May 30, 2022

RE: Sandia Peak Grid BESS Facility
7880 & 7850 Jacs Lane NE
Traffic Circulation Layout

We received your March 24 letter with comments and requests for additional information on the Traffic Circulation Layout for our proposed Sandia Peak Grid BESS facility. This letter and the attached documents provide responses to the items you raised. Your comments are copied below *in italics*, followed by commentary on how each of these items was addressed.

ABLE GRID	JOB NUMBER	REV
SANDIA GRID PROJECT	172221	E
SITE PLAN	DRAWING NUMBER	C1-2

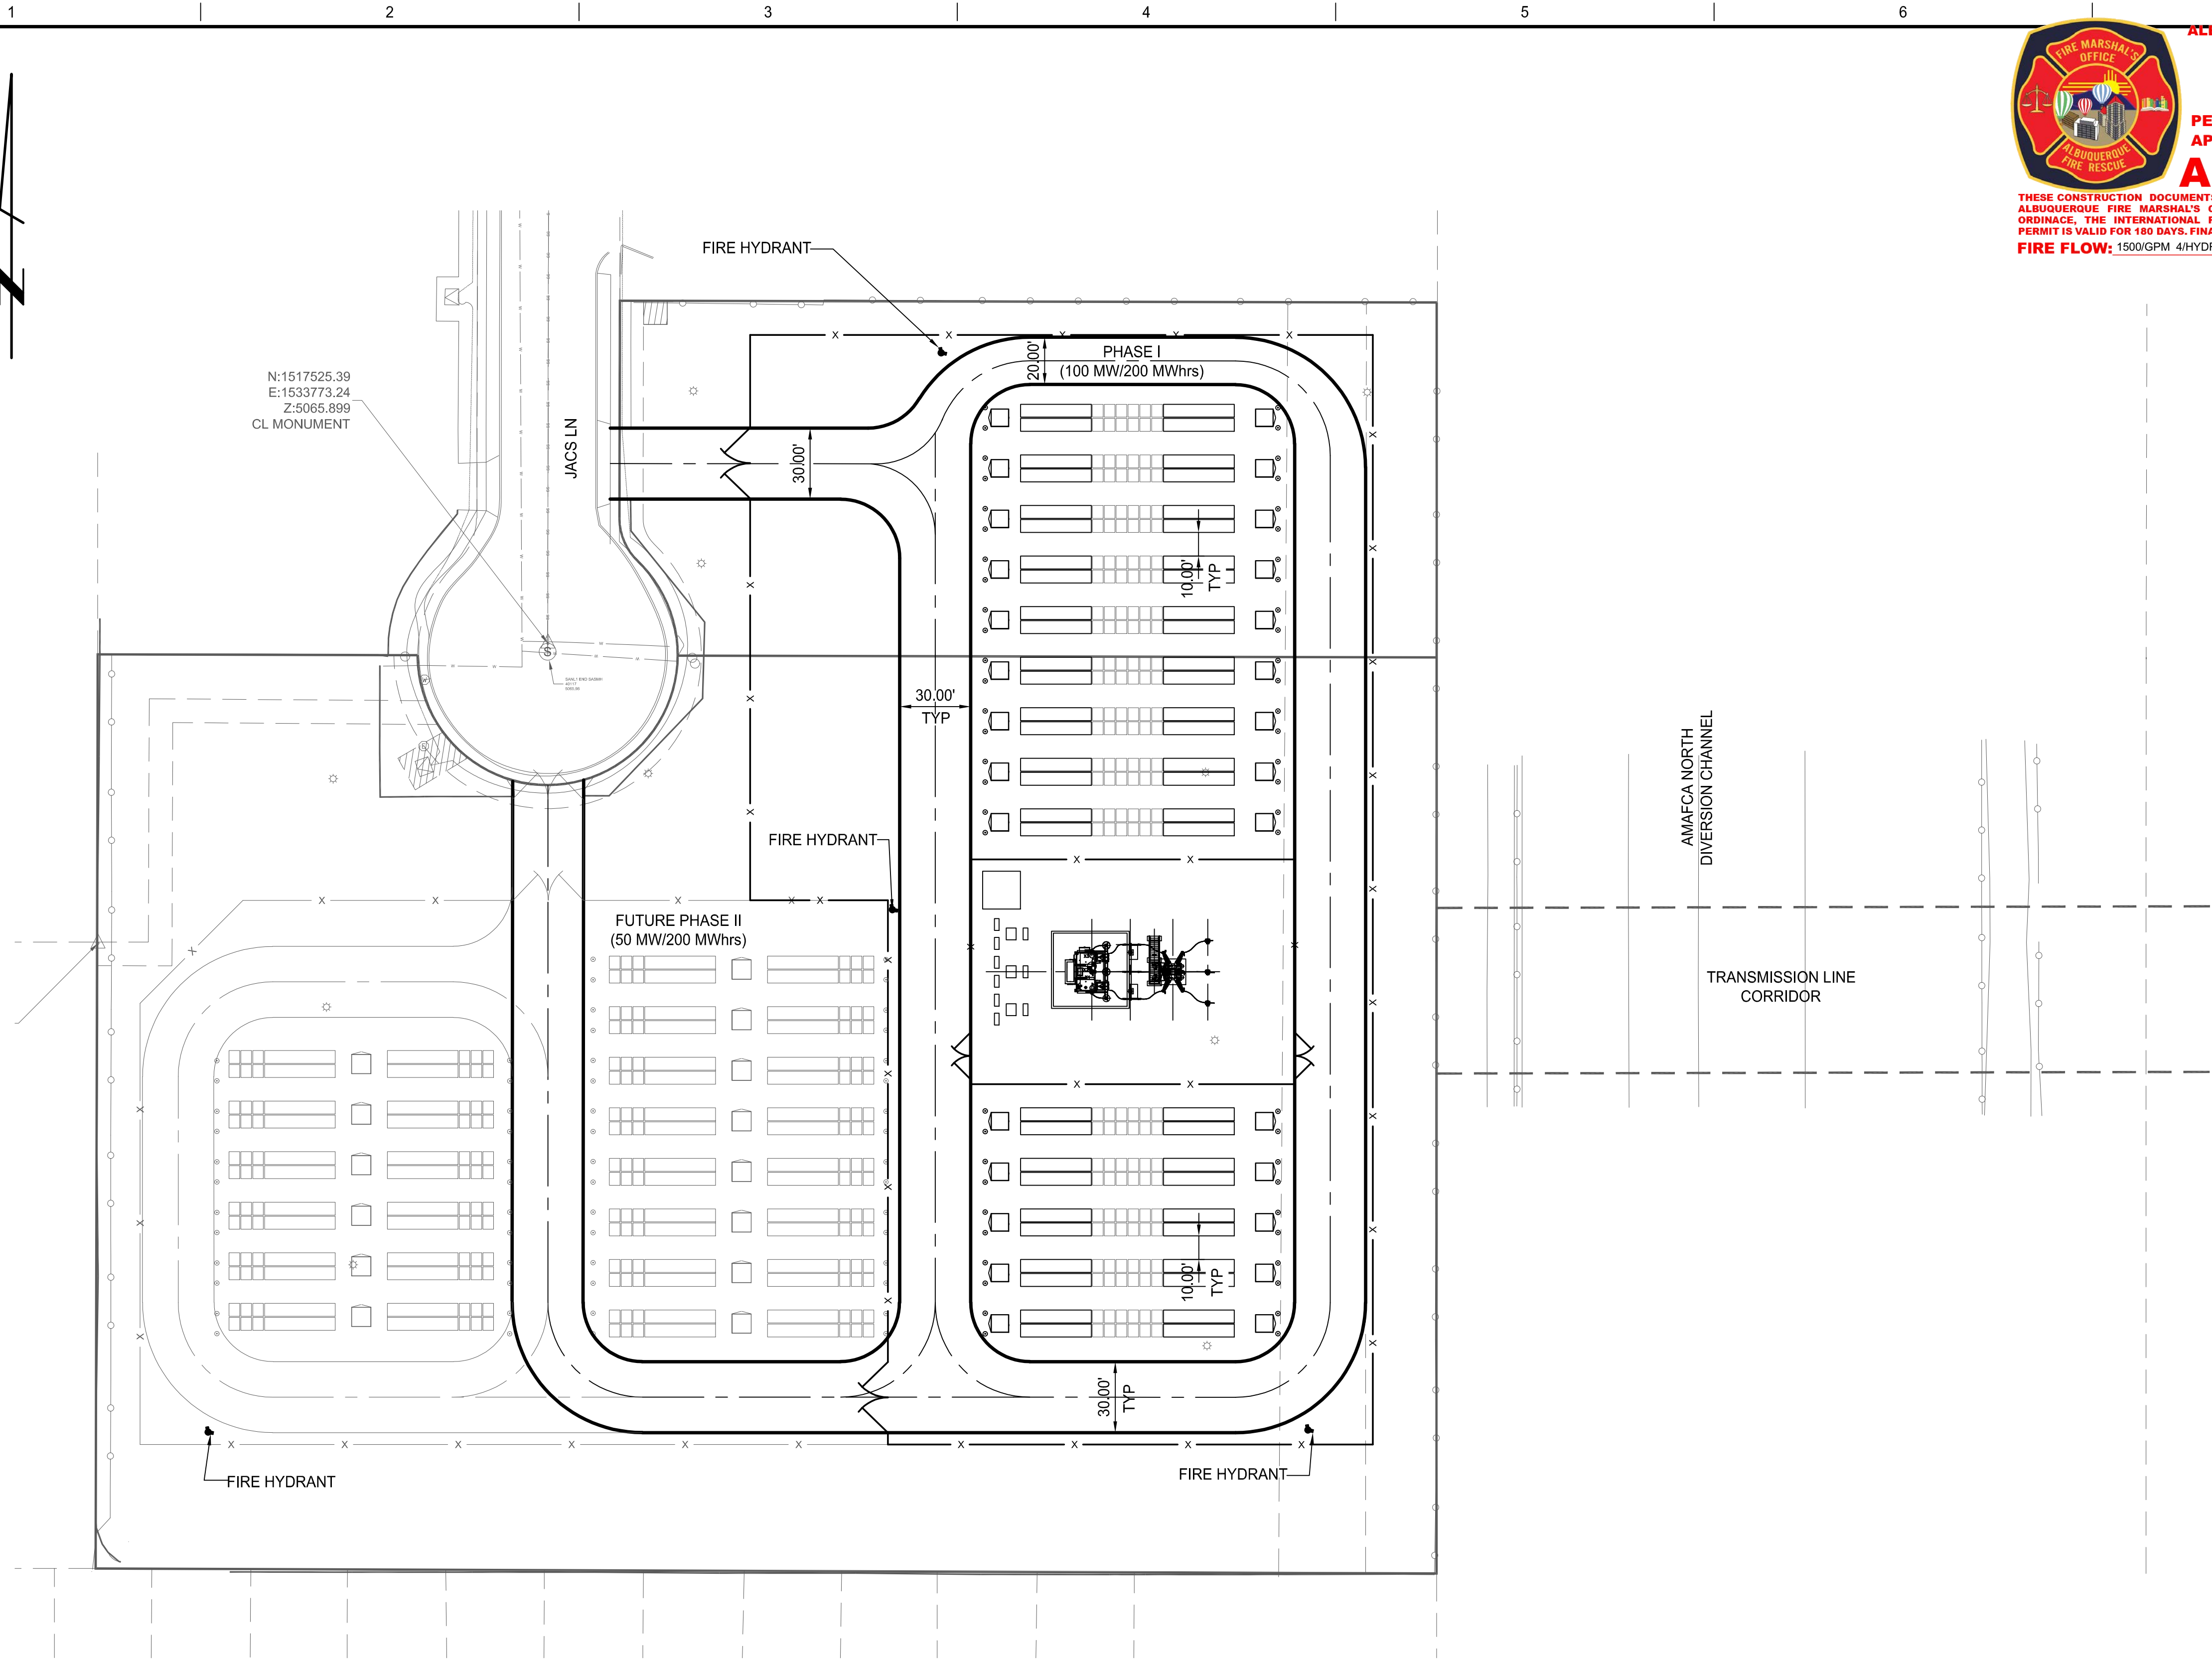
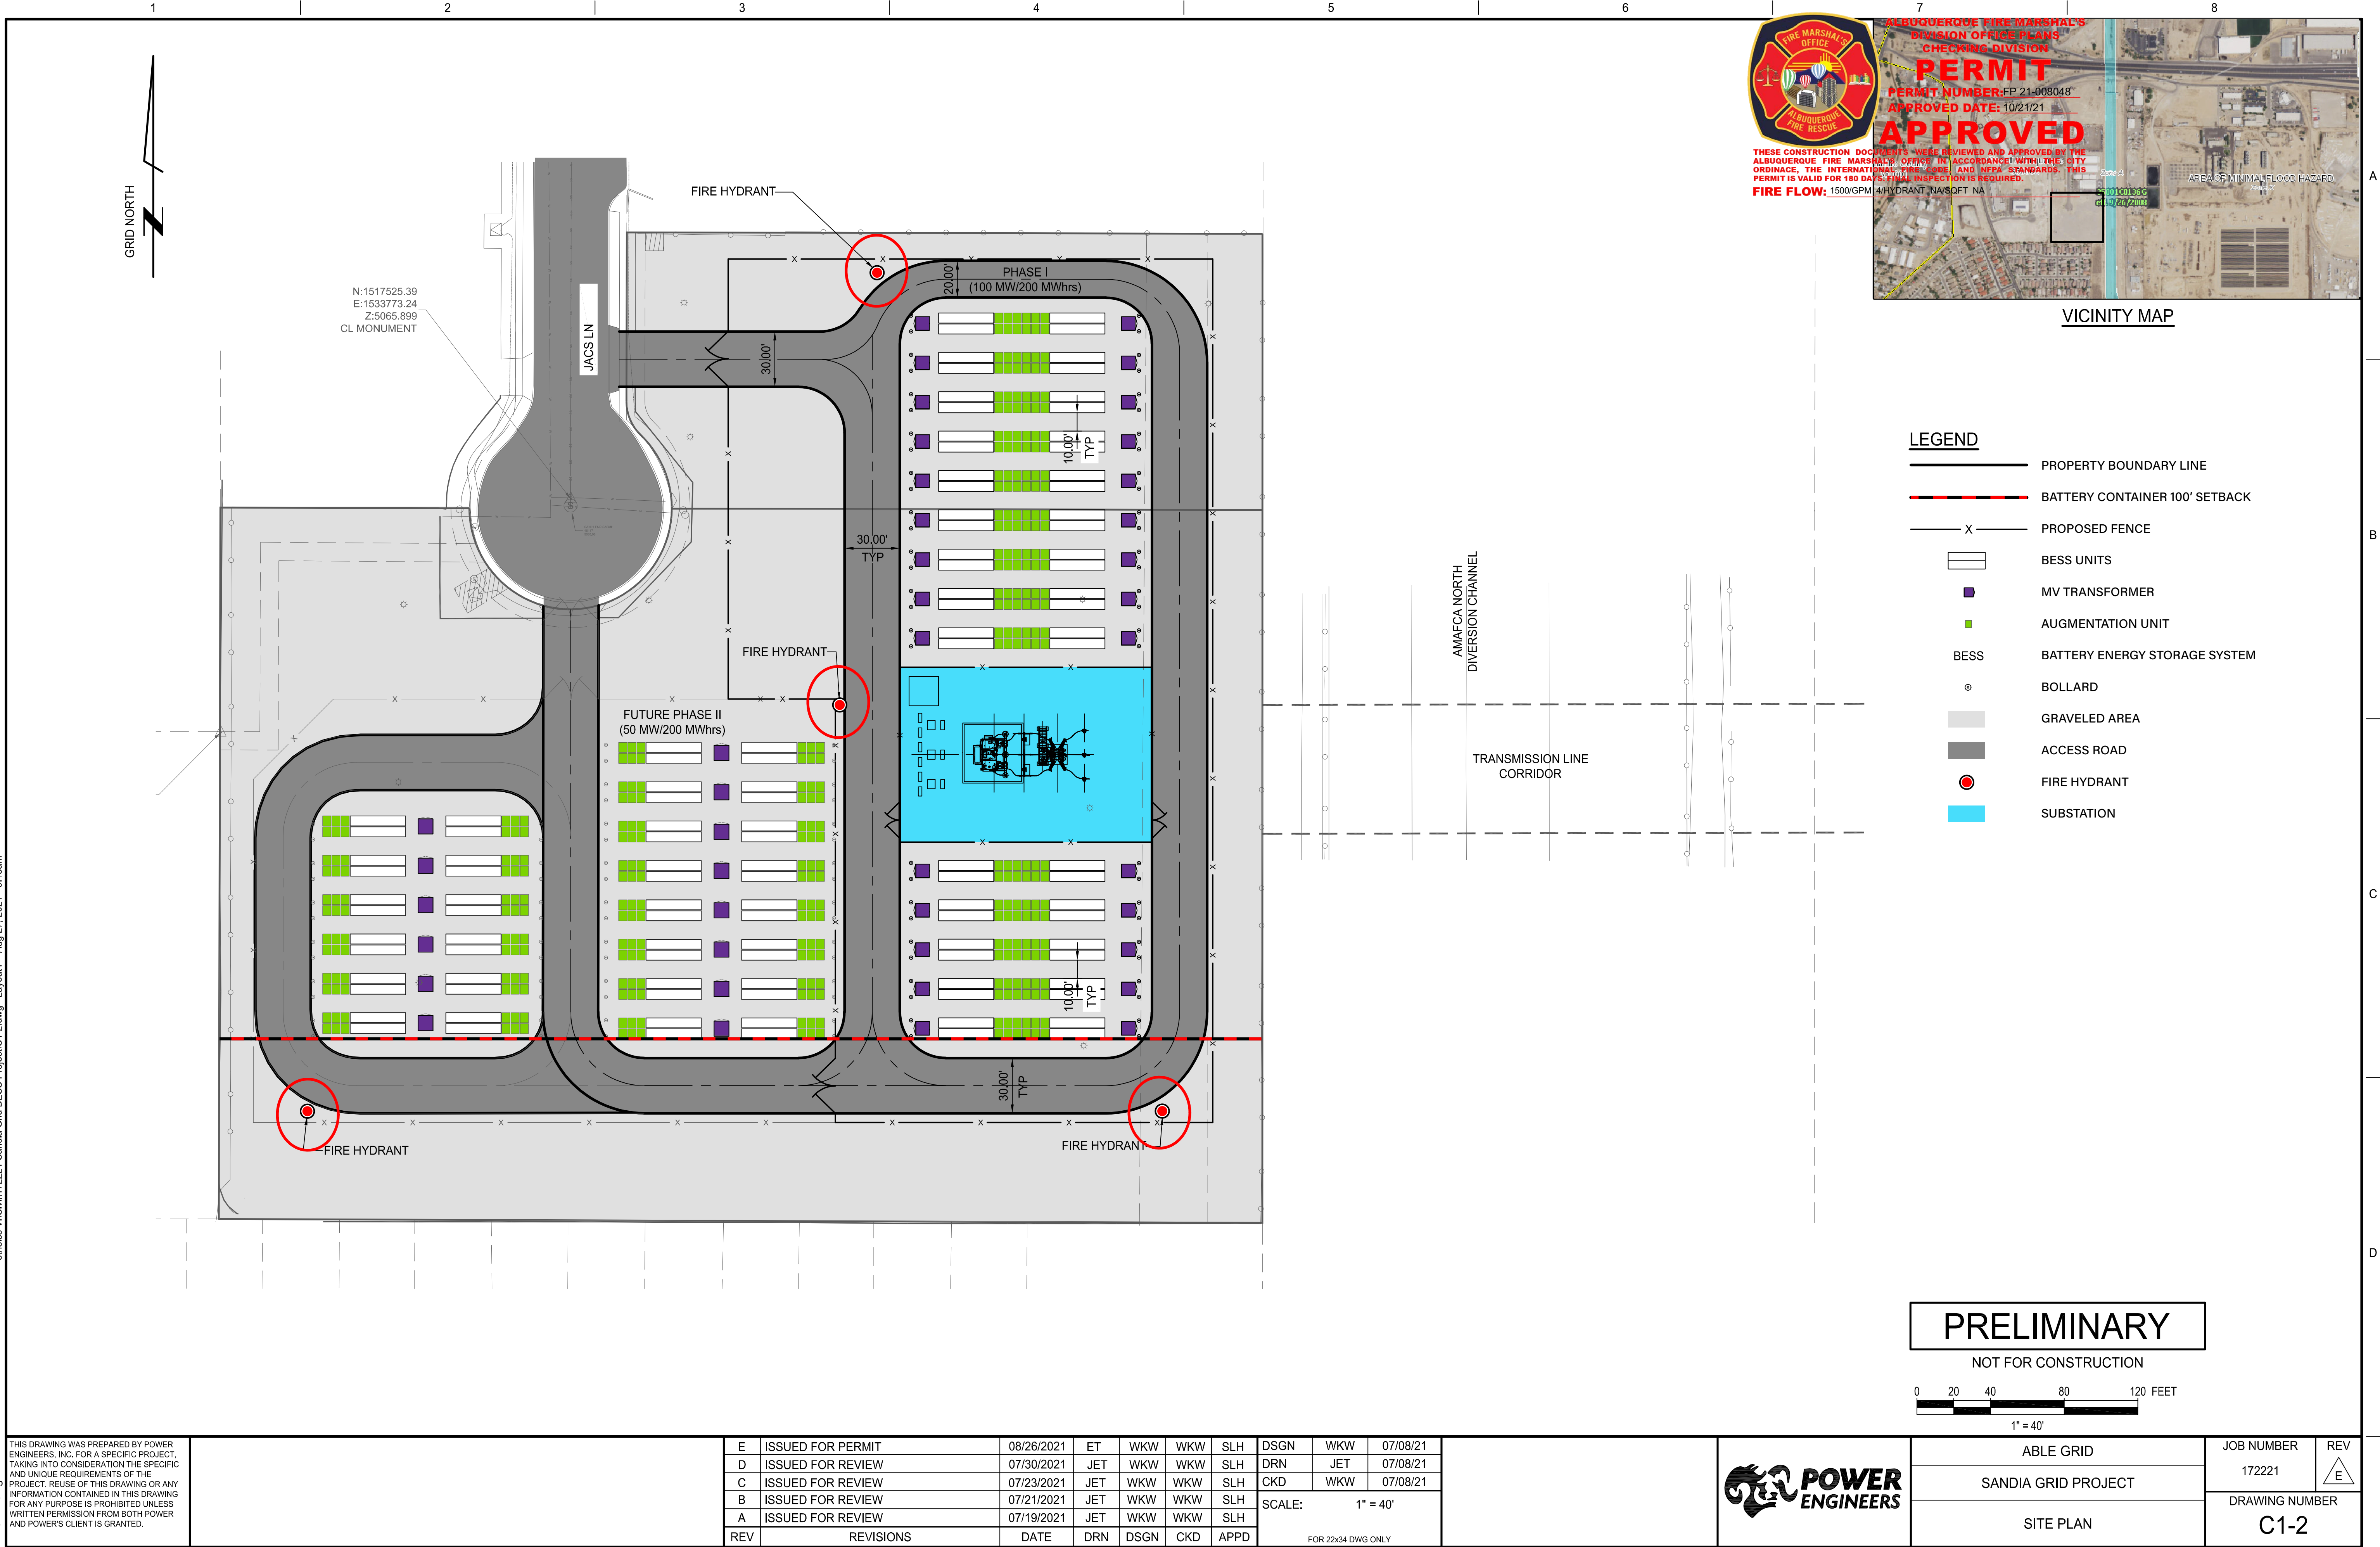
3. *The minimum drive aisle dimensions are shown below (YOU HAVE PROVIDED ONLY 20 FT WIDTH, PLEASE JUSTIFY).*

All internal drive aisles are 30 ft in width, except for the short segment around the northeastern end of the BESS yard which is 20' in width. This segment of drive aisle was narrowed in order to accommodate the required 10 ft setback between the property line and the BESS fenceline per IDO 4-3(E)(8), while maintaining a 100 ft setback of the batteries from the southern property line and required equipment spacing. This segment of road can be designated as a fire lane.

ABLE GRID	JOB NUMBER	REV
SANDIA GRID PROJECT	172221	B
PRELIMINARY GRADING AND DRAINAGE PLAN	DRAWING NUMBER	C3-1

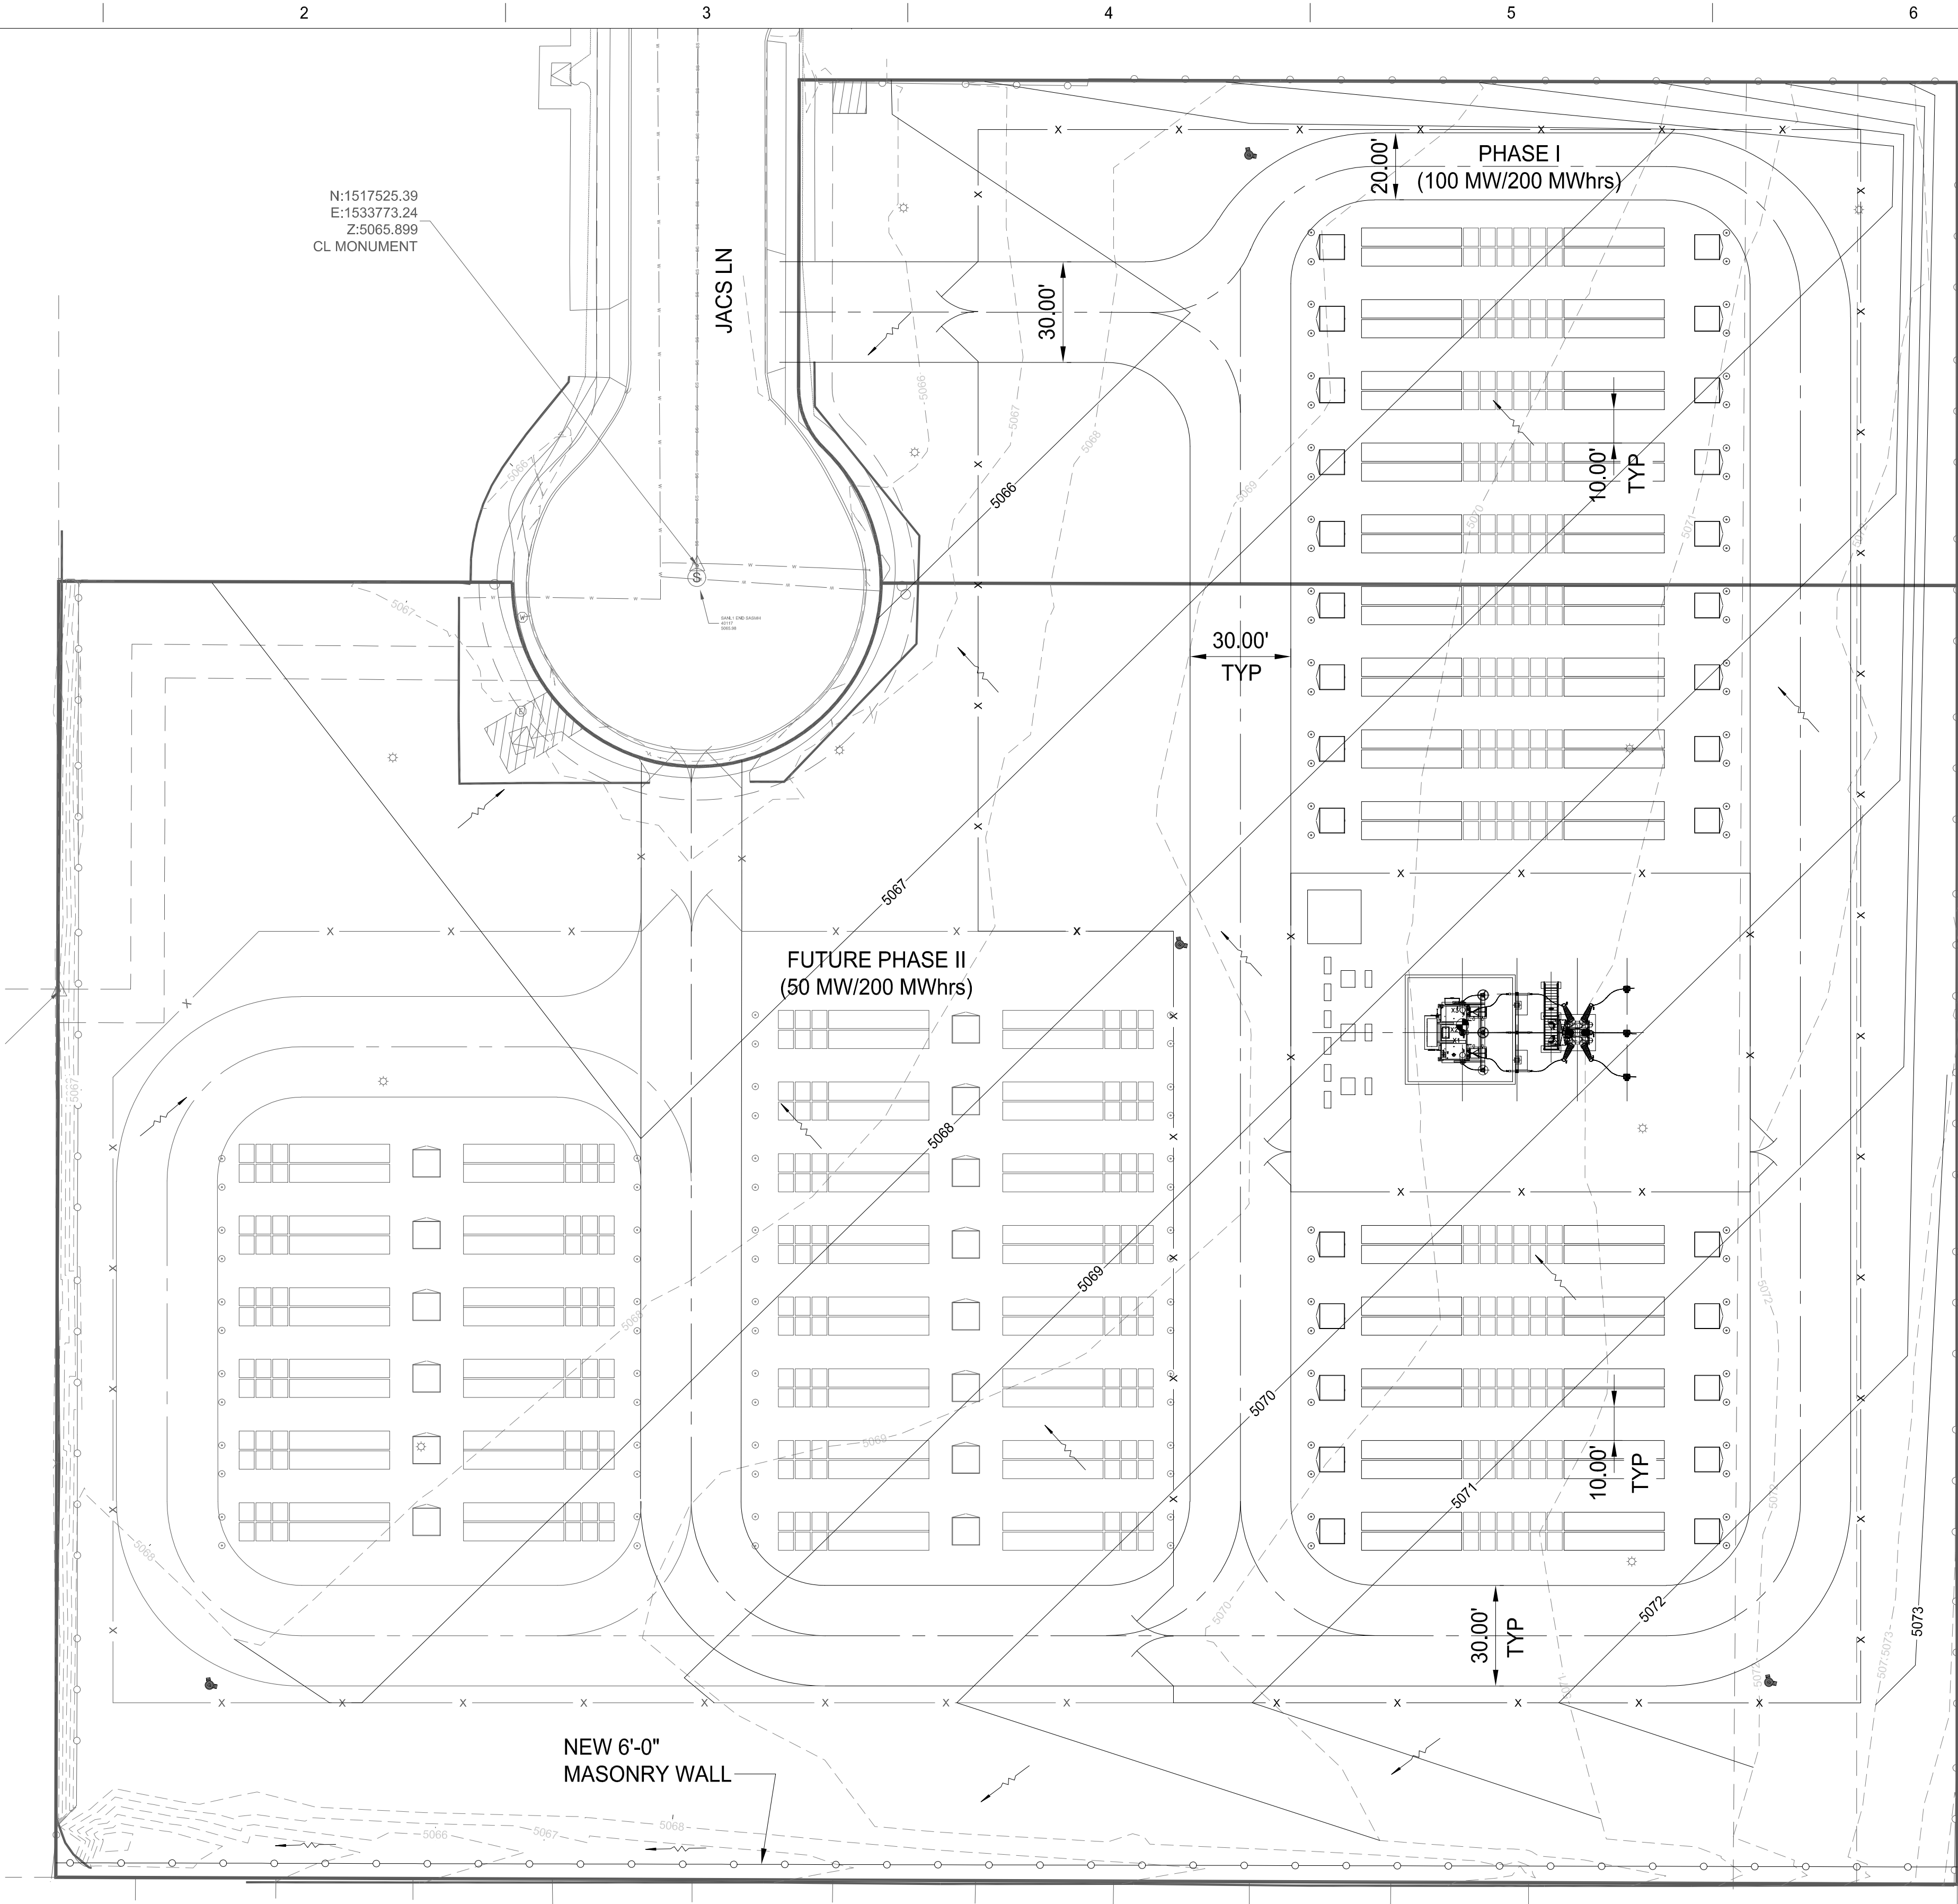
6. *Fire Department: An approved Fire 1 plan needs to be provided.*

The approved Fire 1 Plan is provided.
